EP-22-0022_1 Latigo Trails Filing 10 SF2136

Proposed: 39 single-family lots within 107 acres

Submitted 11/17/2021 by Amy Crandall, Engineering Geologist, Colorado Geological Survey (303-384-2632 or acrandall@mines.edu)

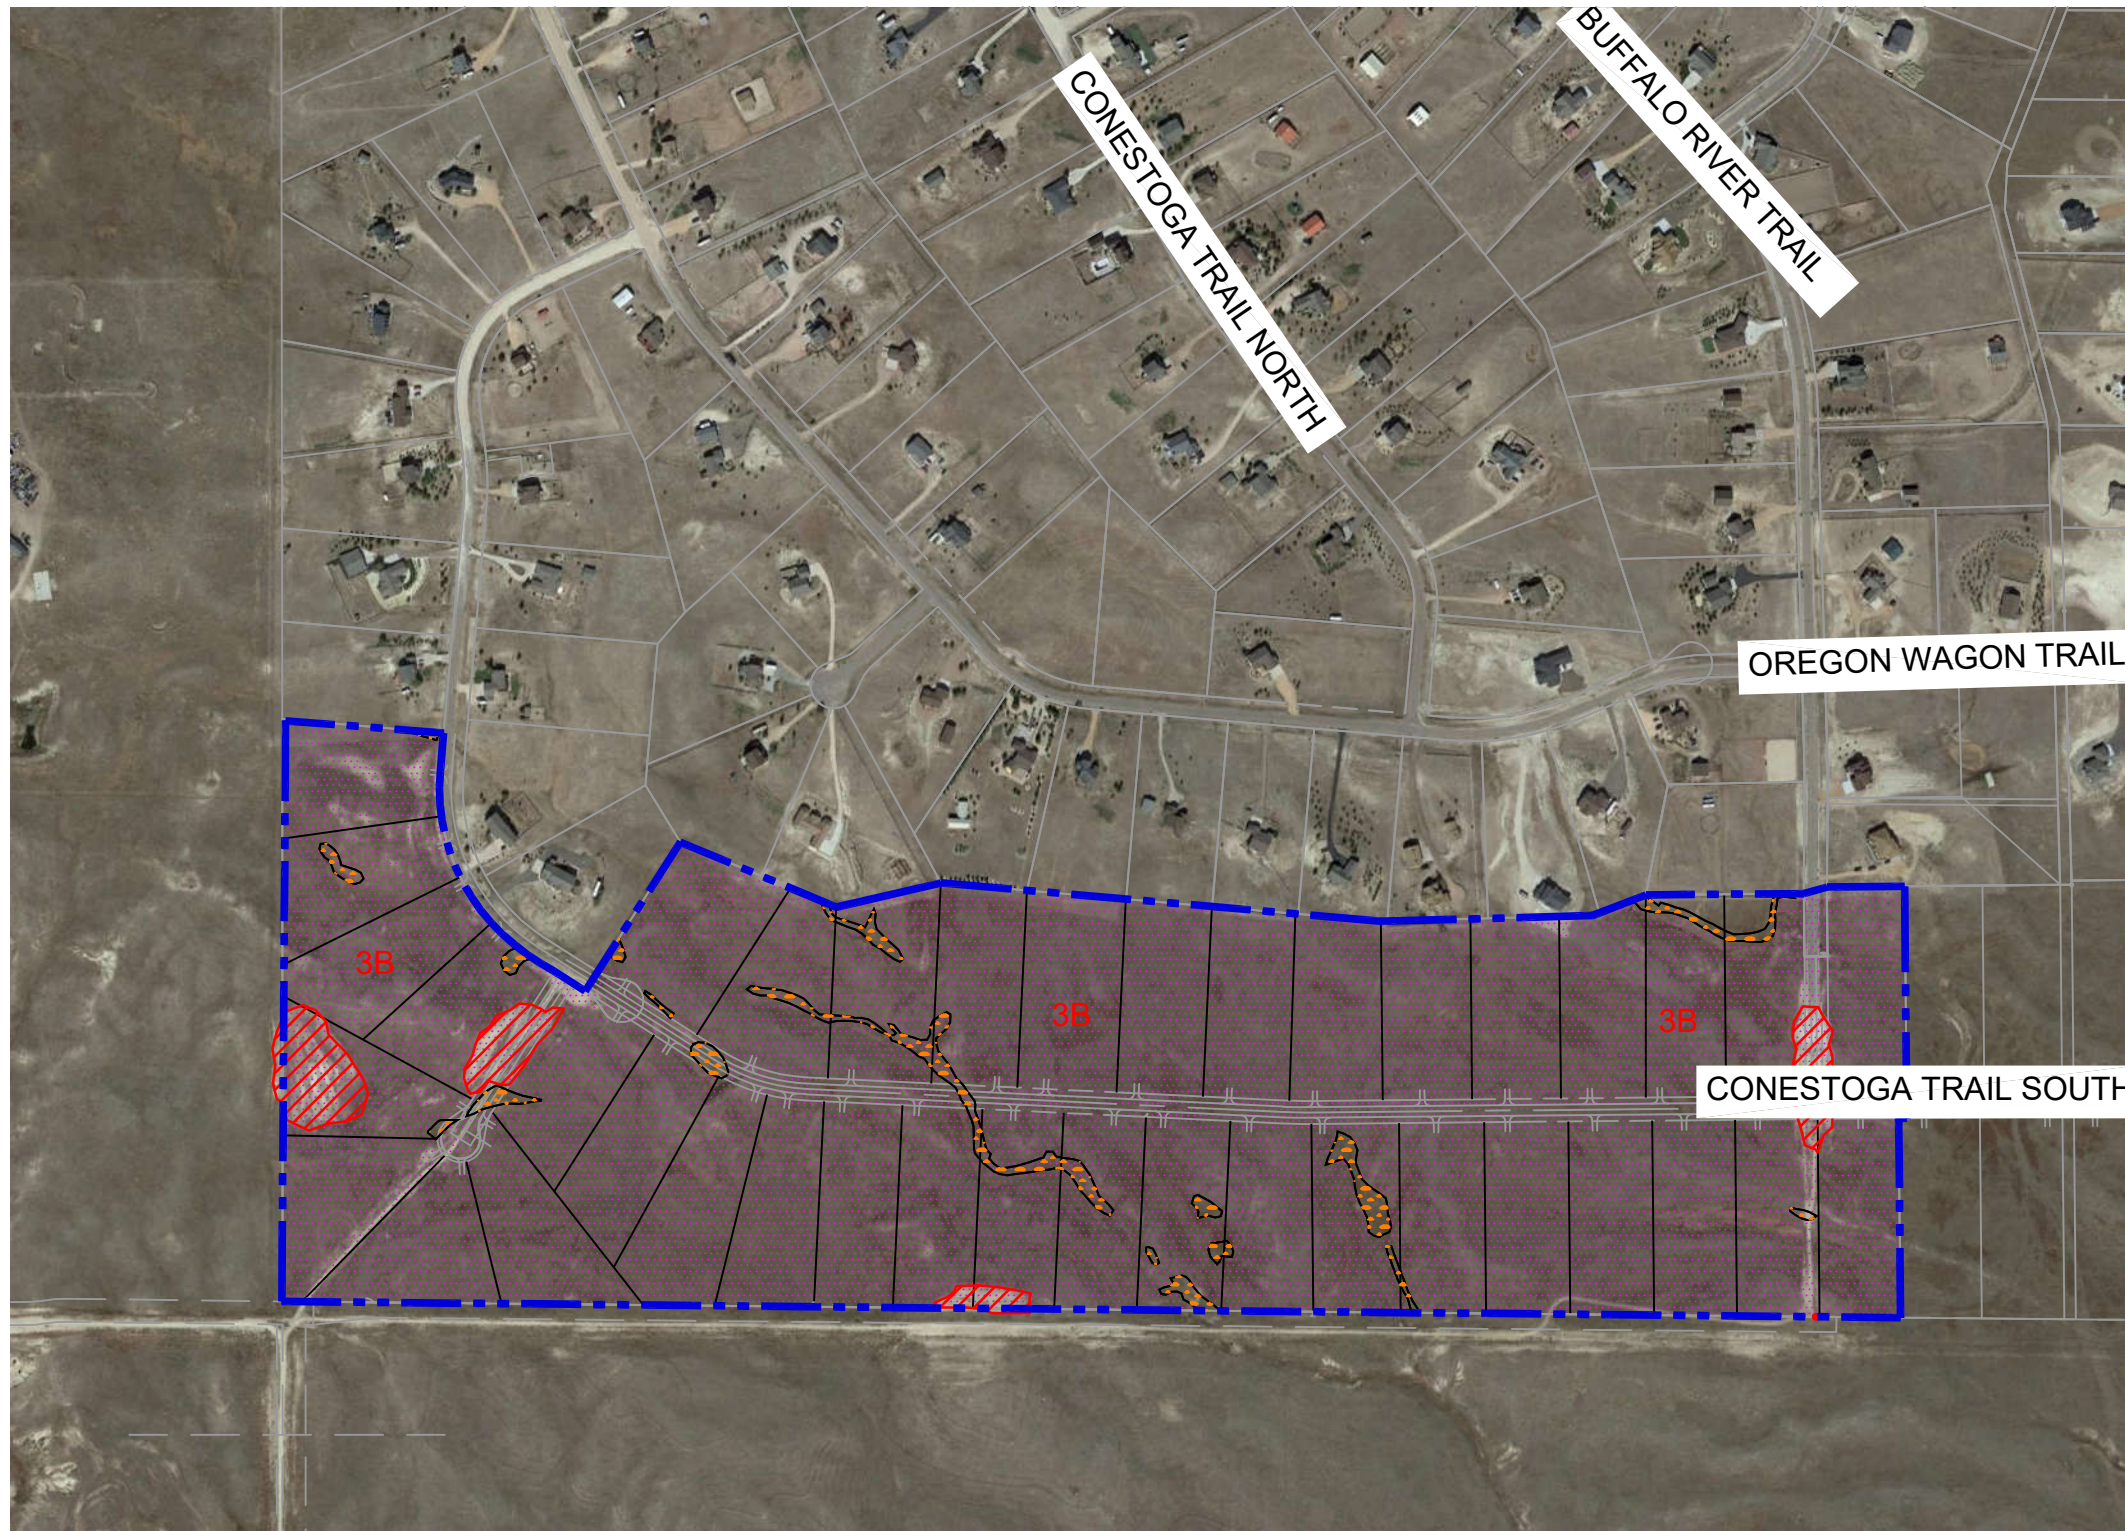
Groundwater Conditions. CTL states on page 7, "We expect shallow groundwater will not present a significant or widespread constraint within the development; however, areas of seasonally high groundwater may be present near drainages." CGS agrees with CTL (page 7) that "perched groundwater may develop after development where more permeable granular soils overlie less permeable bedrock." We also agree with CTL on page 10, "Localized areas of potentially seasonal shallow groundwater can be avoided by siting the residences away from these areas (near drainages)."
